Sent: 27 September 2013 10:55
To: Planning
Subject: Planning application S6/2013/1915/FP - TESCO EXPRESS 59 Station Road

Response to Planning application from Hertfordshire County Council (T and CP GDP Order 1995)

Installation of ATM pod and erection of 15x security bollards

Figure 1 – Proposed External Works

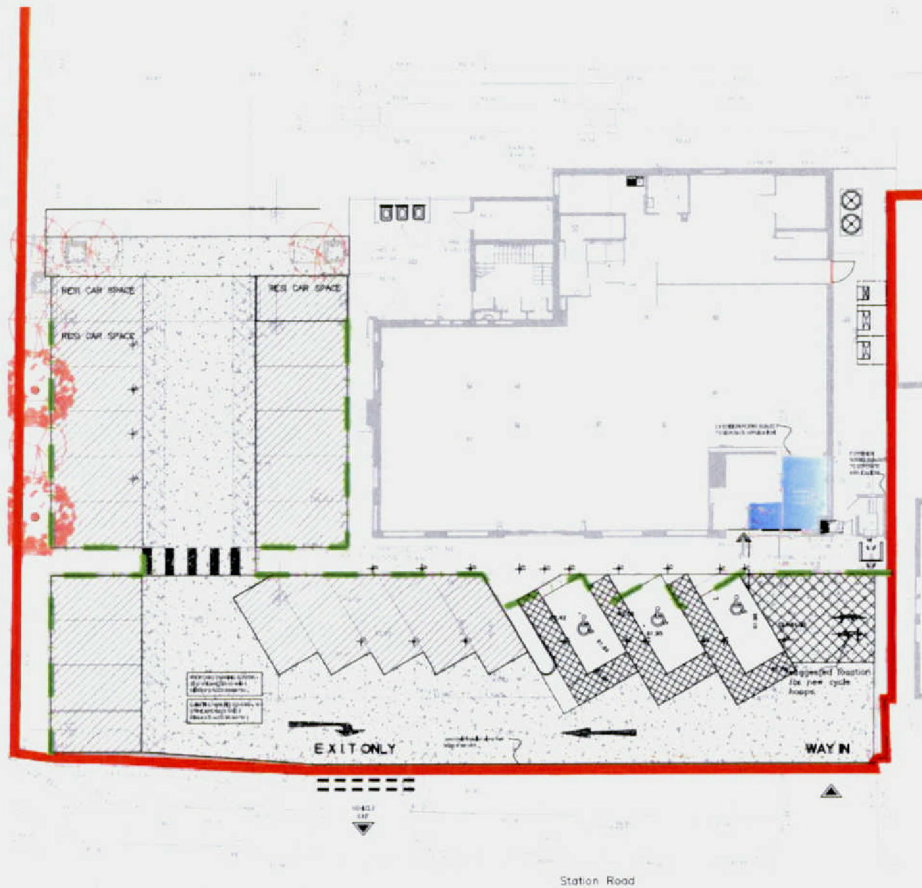
Although the Highway Authority has no objection to the principle of relocating the ATM and providing bollards, there are details shown on drawing number F9D12-161(00)111, which do cause concern and may impact on the highway. Planning permission should not be granted until these issues are resolved.

The drawing shows the cycle racks being relocated to the area that is currently designated for delivery vehicles. The loss of this space would result in delivery vehicles entering the site overhanging the public footway rather than being able to fully enter the site. The drawing seems to show two rows of bollards, 18 in total, rather than the 15 mentioned in the application form, one at the edge of the footpath in front of the shop, which is acceptable, however a second row appears to be placed in the parking bays and although some lie between two parking spaces, others fall in the centre of the bays and therefore the inclusion of these bollards would reduce the amount of on site parking available. Details of which are the proposed bollards should be provided.
